Response to Submissions and Amendment Report 2

IRT Woonona Seniors Housing Redevelopment

4-6 Popes Road, Woonona

18 March 2026 | 2250296

Figure 1 1% AEP water level afflux from ACOR RFI Response (4 December 2025). (Max water level increases provided by ACOR on 6 March 2026).

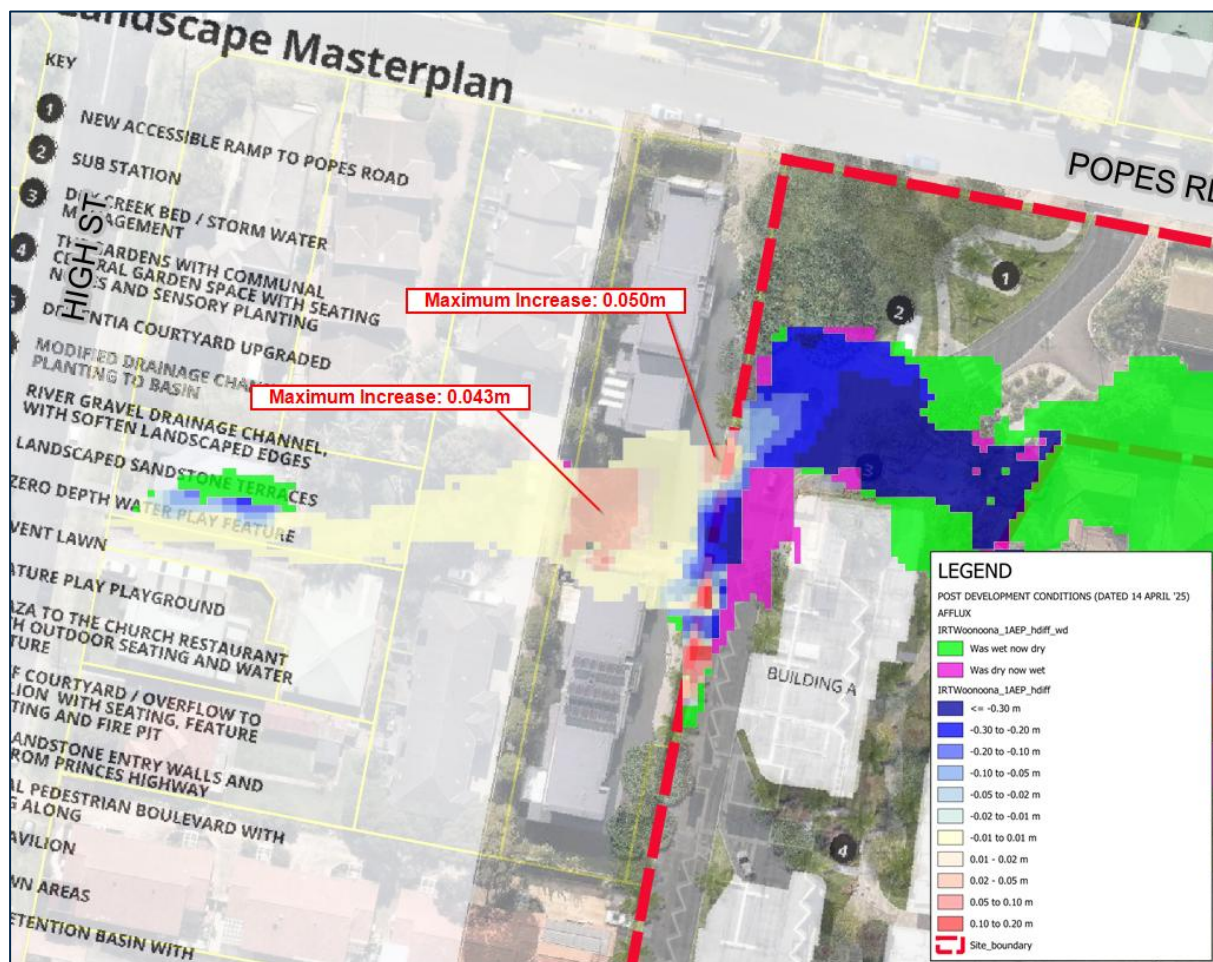
Issue Raised	Response
Flood and stormwater management	
<p>Wollongong Local Environmental Plan 2009. The Department notes from Section 5 (and associated modelling) of the Flood Report prepared by Acor, dated 26 May 2025 that the proposal is likely to increase flooding impacts upstream of the western boundary. Please investigate and resolve this likelihood of upstream flooding, having regard to clause 5.21 of the</p>	<p>A Response to Submissions Letter has been prepared by ACOR and is provided at Appendix J. It is noted that the flood impact maps were updated and presented in ACOR letter <i>IRT Woonona – SSDA Response</i> dated 4 December 2025, under RtS and Amendment Report 1.</p>

The letter notes that in response to Clause 5.21 of the Wollongong Local Environmental Plan 2009 (**WLEP 2009**), an inspection of the model results shows that increases in water level in the 1% AEP event on 2 Popes Road, upstream of the western boundary, are between 10-43mm and are contained in a localised area of the open channel upstream of the inlet of the culvert under the driveway. These localised impacts are not likely to cause an actionable nuisance and do not have the potential to worsen the use or enjoyment of the land. Flood impacts are not evident upstream of the western boundary for the 20% AEP event, and negligible and localised within the open channel in the 10% and 5% AEP events.

This response has been corroborated by an independent peer review undertaken by Martens and provided at **Appendix O**. The Response to Submissions letter prepared by Martens includes reproduced flood impact maps of the 1% AEP water level afflux and 1% AEP with climate change impacts, to the west of the site, including the maximum water level increases.

The response confirms that the impacts further west are confined to within the open channel. Impacts closer to the site boundary are confined immediately behind a solid brick wall north of the existing fence opening. Further, the letter confirms the existing hazards in this area remain unchanged by the proposed development and will not impact the safe use of the driveway. As such, Martens conclude that the impacts are acceptable.
